**Subject: Response to Submissions 2 – Alspec Warehousing Facility (SSD-81434988)  
(Penrith)**

## CPHR comments on Response to Submissions – Alspec Warehousing Facility (SSD- 81434988) (Penrith)

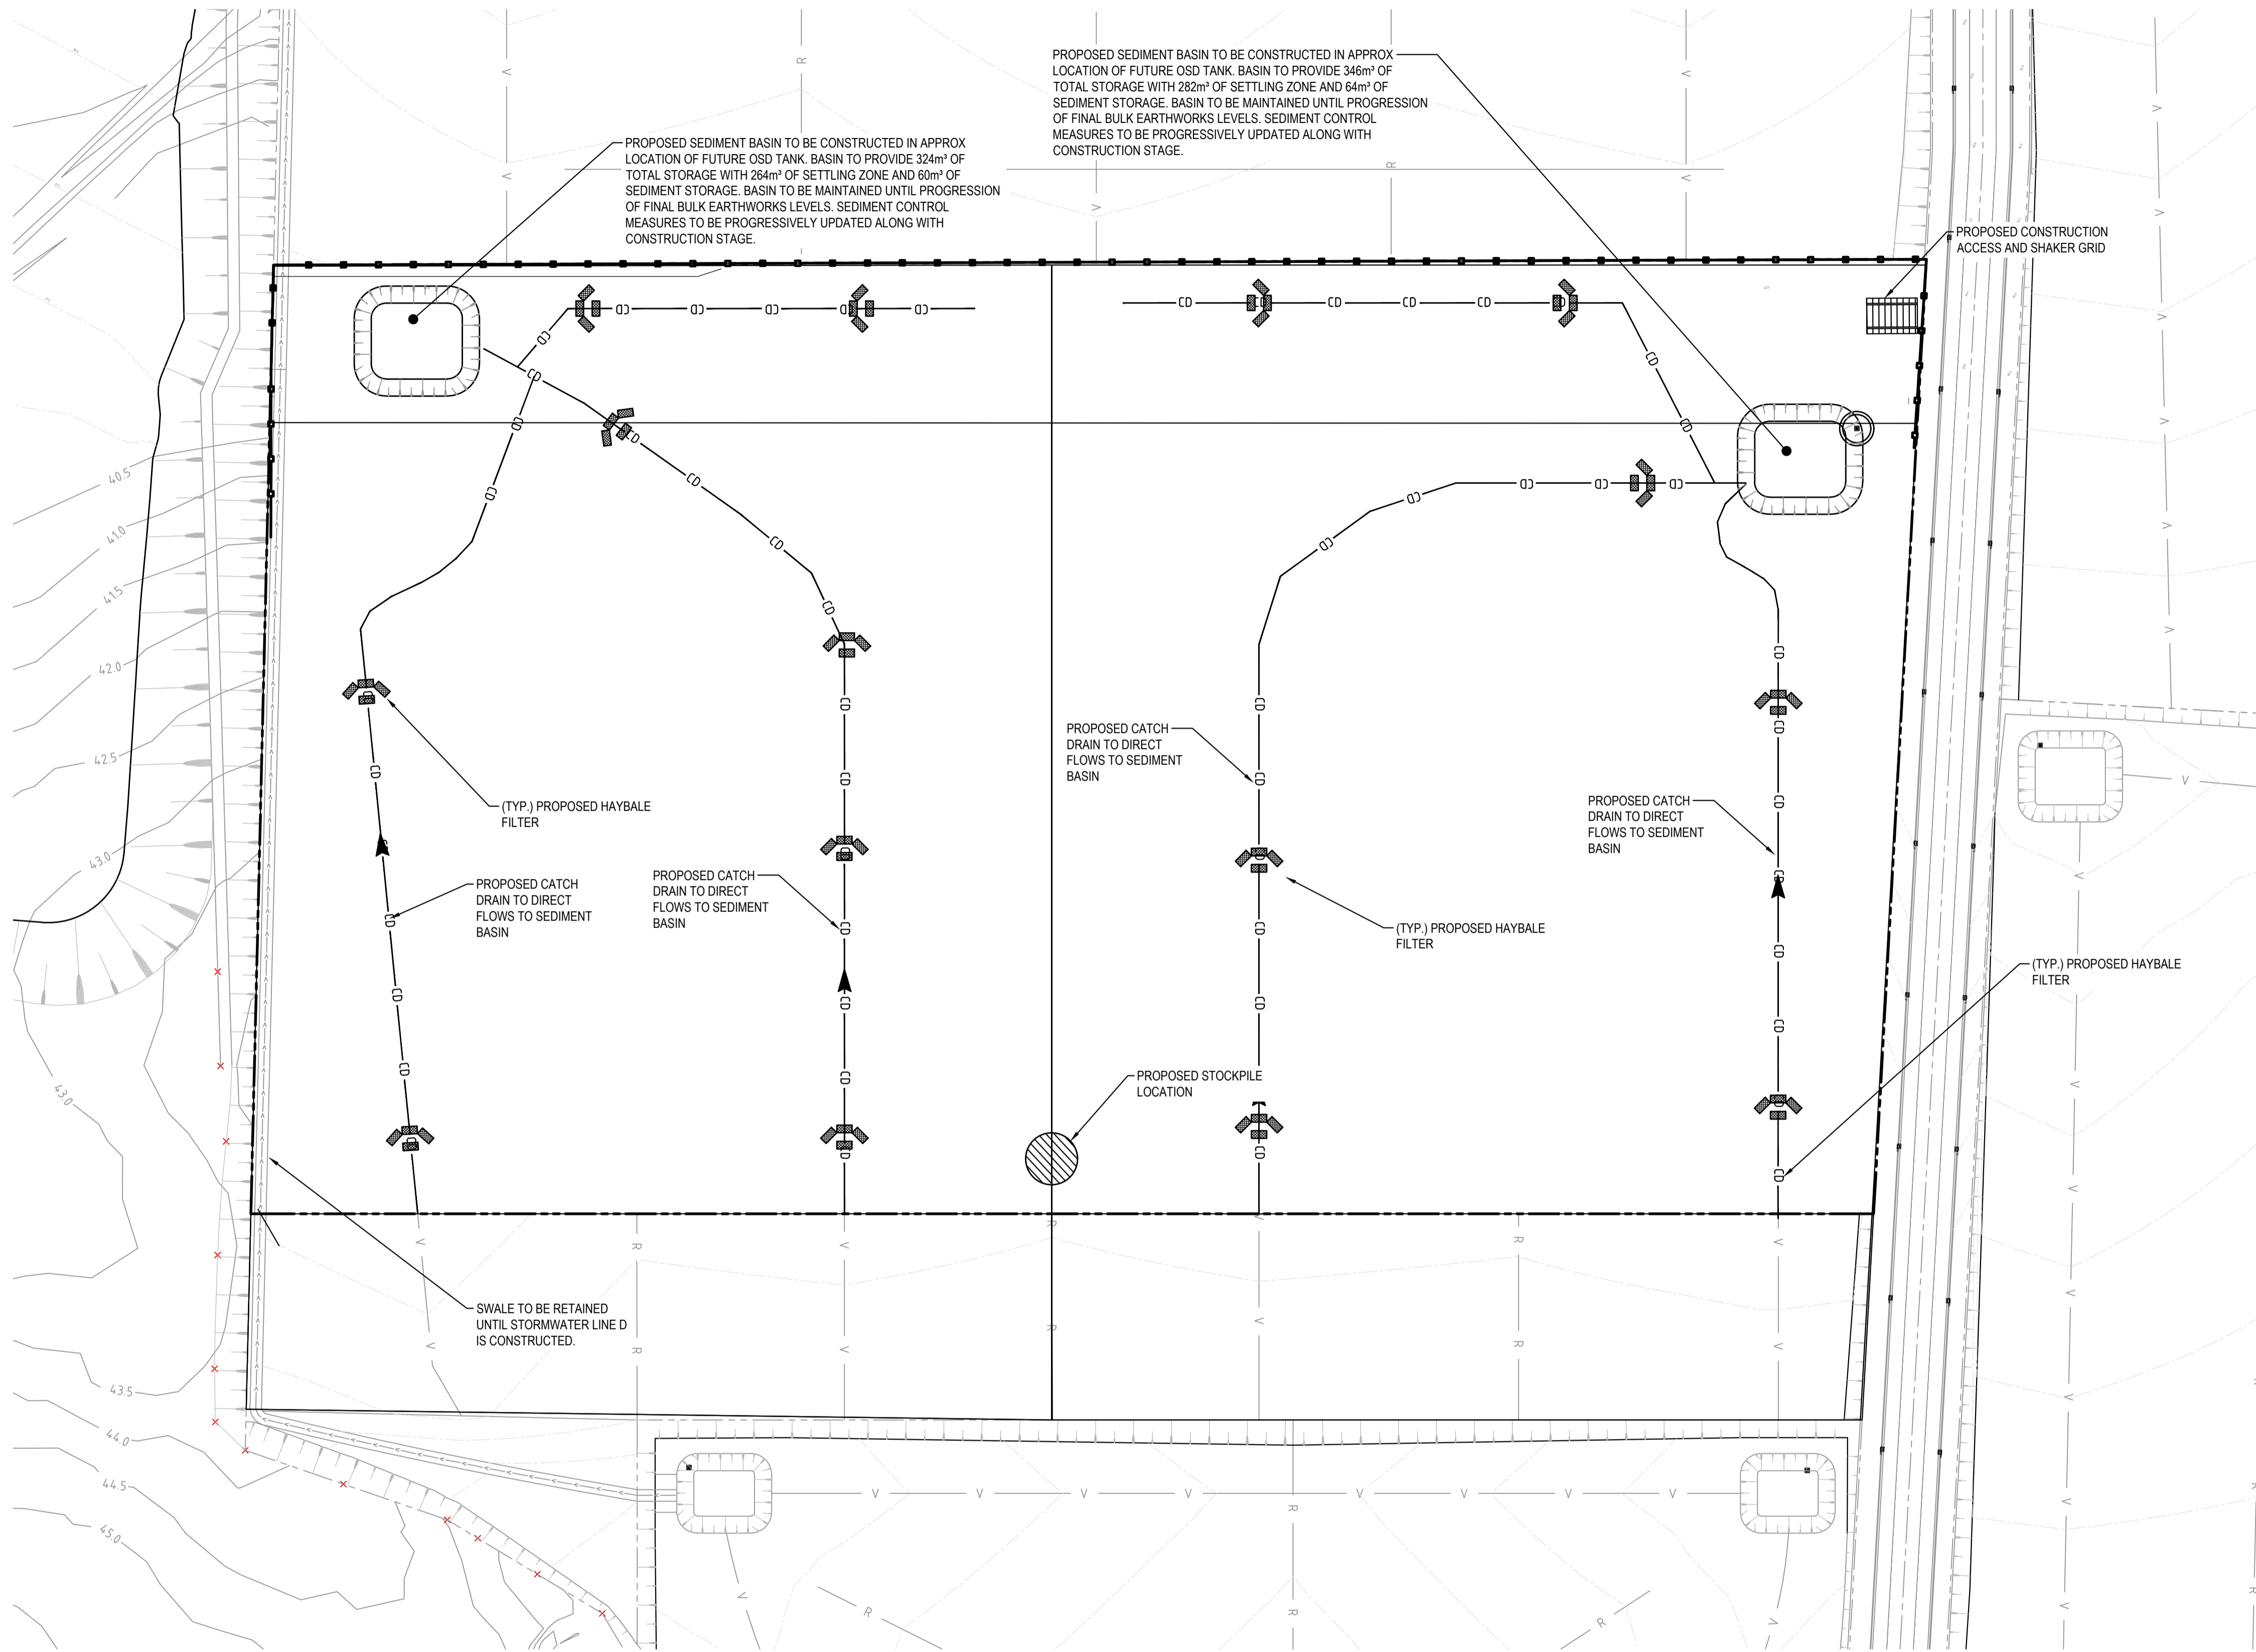
- CPHR reiterates that insufficient information has been provided on the interim stormwater management strategy to demonstrate how the construction phase stormwater quality targets in [Technical guidance for achieving Wianamatta-South Creek stormwater management targets](#) will be achieved.

1.	<i>Interim stormwater management strategy</i>	<p>The proponent has provided the ultimate operational stormwater strategy in the RTS response. CPHR requires the interim stormwater management strategy to determine that construction phase stormwater quality targets will be met.</p> <p>To demonstrate the construction phase stormwater quality targets will be met, a detailed erosion and sediment control plan (ESCP) must:</p> <ul style="list-style-type: none"> <li>• be developed and certified by a Certified Professional in Erosion and Sediment Control or a qualified and experienced civil engineer with at least 5 years' experience in the development of site-specific soil and water management plans</li> <li>• illustrate appropriate controls, that when implemented will achieve the construction phase stormwater quality targets in Table 2 of the <a href="#">Technical guidance for achieving Wianamatta-South Creek stormwater management targets</a> (DPE, 2022)</li> <li>• be prepared in accordance with the Blue Book (NSW Government 2004)</li> <li>• be prepared in accordance with the Water Sensitive Urban Design (WSUD) design considerations set out in Chapter 3 of the Tech Guide (especially WSUD measures) provide conceptual designs that include the site, catchment and key features of the ESCP on scaled drawings.</li> </ul> <p><b>Recommended action:</b></p> <ul style="list-style-type: none"> <li>• Provide detailed ESCP and associated design drawings demonstrating compliance with construction phase stormwater targets.</li> </ul>
